Arun District Council
Arun Civic Centre
Maltravers Road
Littlehampton
West Sussex BN17 5LF
Planning & Building Control General Enquiries
Tel: (01903) 737756 Fax: (01903) 730442
Dx: 57406 Littlehampton
Minicom: 01903 732765
e-mail: planning@arun.gov.uk
website: www.arun.gov.uk/planning

Application No: LU/247/20/PL
Site Address: 57 River Road Littlehampton BN17 5DD
Description of works: Partial demolition of existing building, retention of boundary wall & street facade, partial demolition of boundary wall to incorporate new pedestrian gateway & gate, erection of 6 No. flats in 2 blocks connected by shared stair & lift core, on site parking yard for 8 No. cars & 8 No. cycles & space for communal refuse & recycling bins. This application affects the character & appearance of the Littlehampton River Road Conservation Area & is in CIL Zone 4 (Zero Rated) as flats.

Thank you for your internet representation made on 11th October 2020 which has been recorded as an objection with the comments as follows:

TITLE: PROPOSED SOUTH EAST ELEVATION

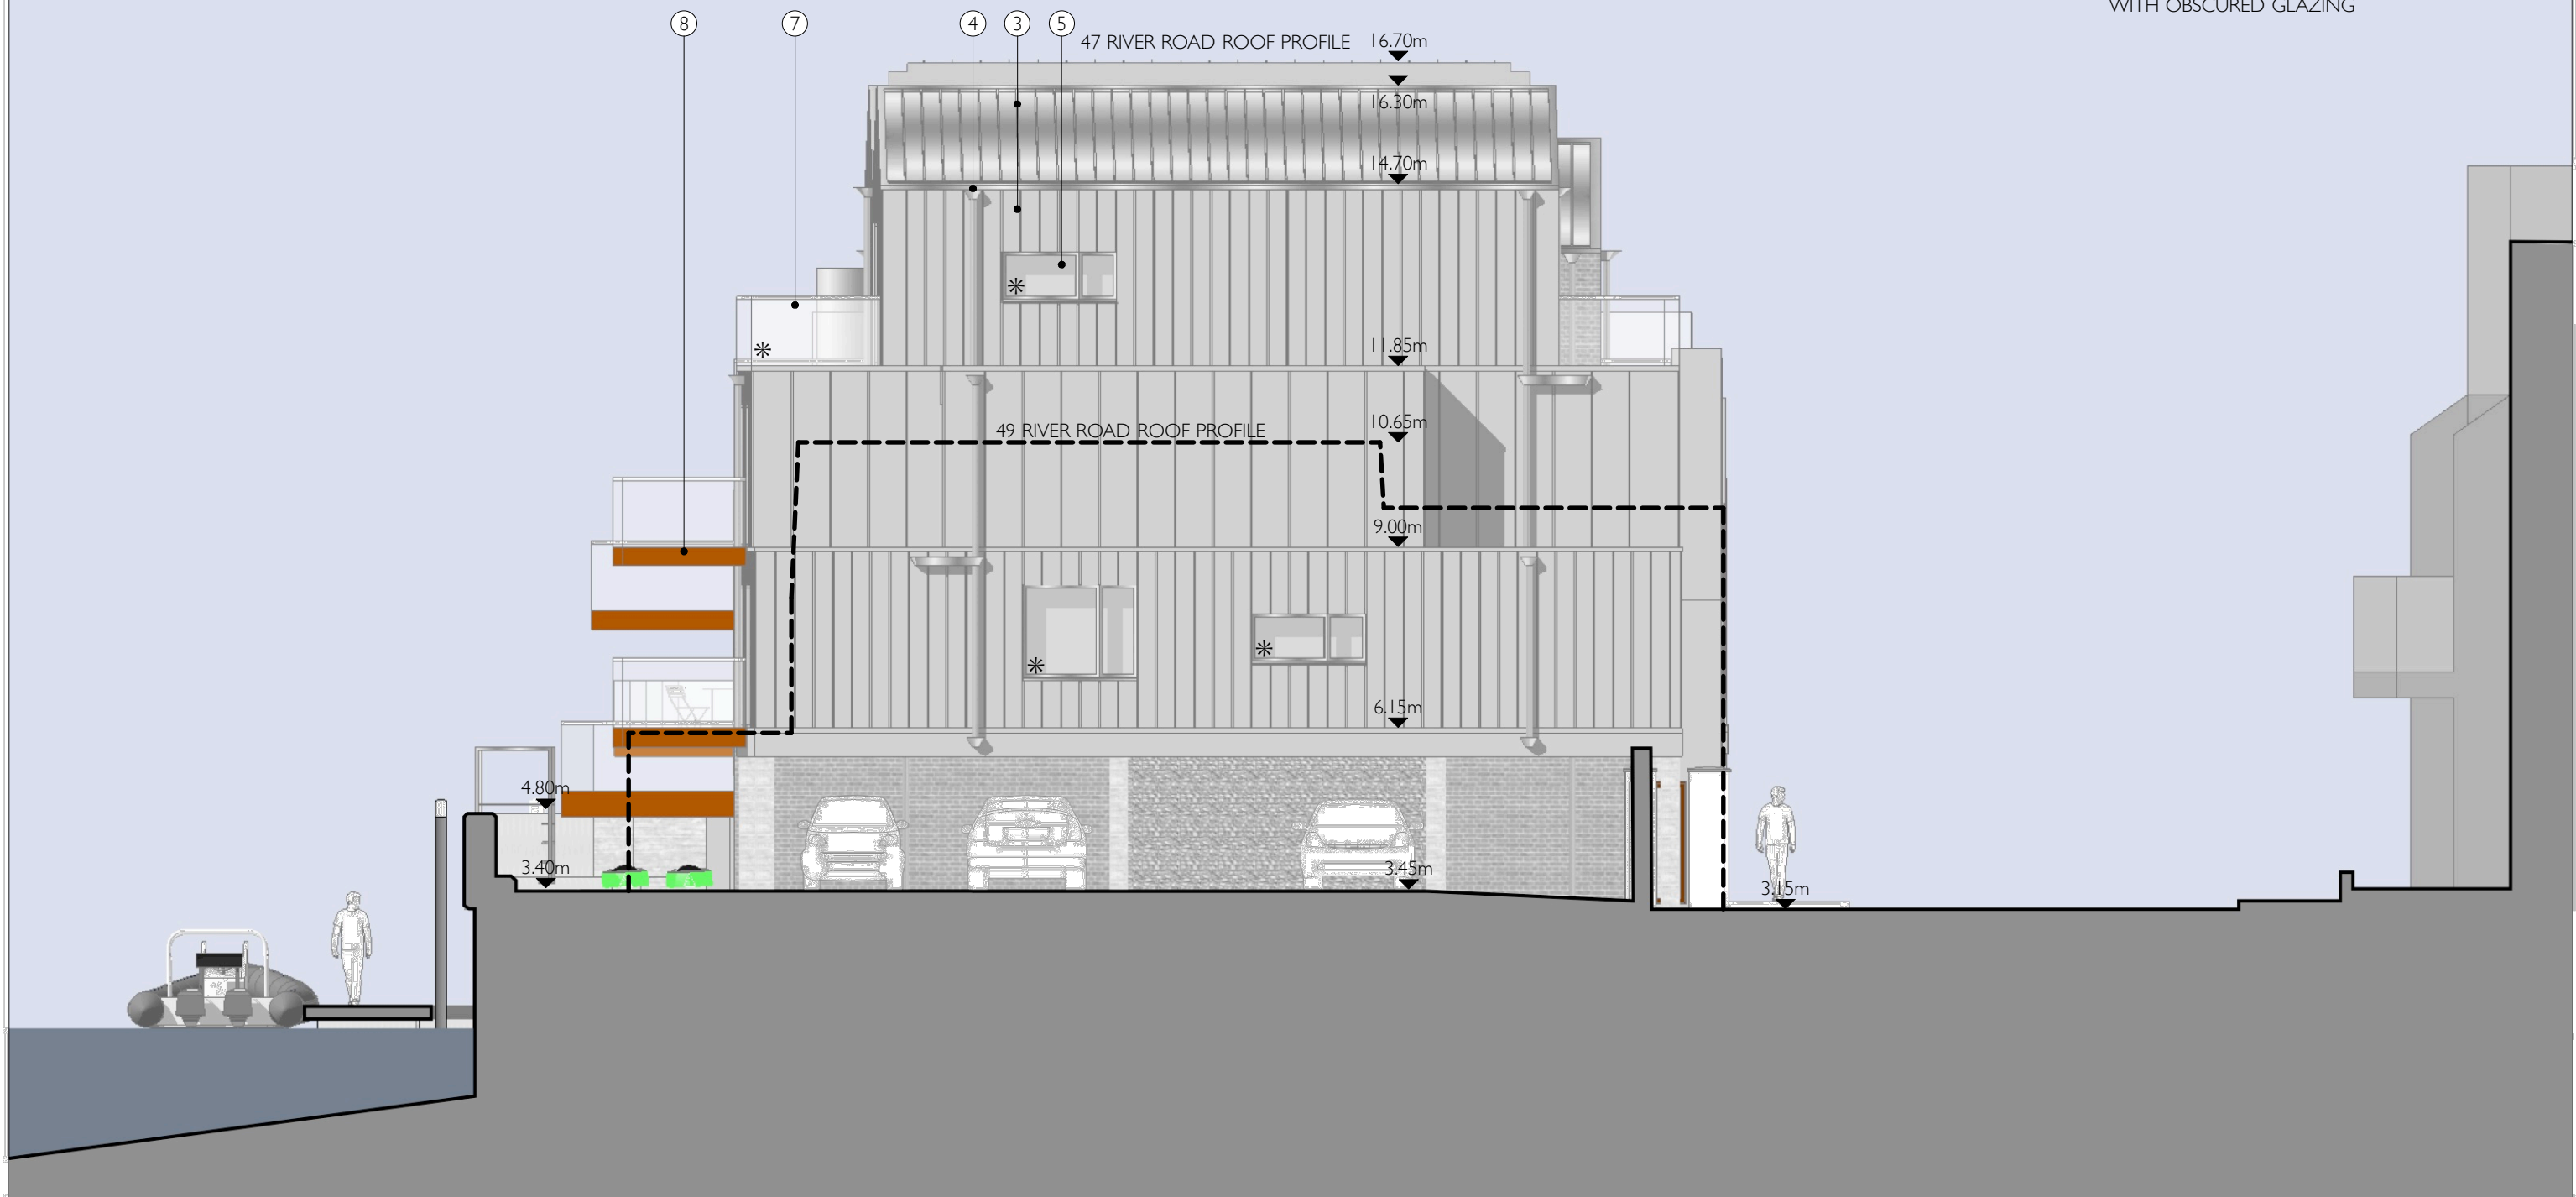
There is no mention on the plans, of the wood stove chimney on the north western roof of 49

This is the main heat source for the accommodation.

Whilst in accordance with the regulations now, it's very likely it will cause nuisance to the proposed neighbouring buildings upper set back amenity terrace.

Given the height of the new building, there will be some down draft issues, depending on wind direction.

For this reason alone, and also the roof light being overlooked.

I do not think access to this flat roof area is viable.
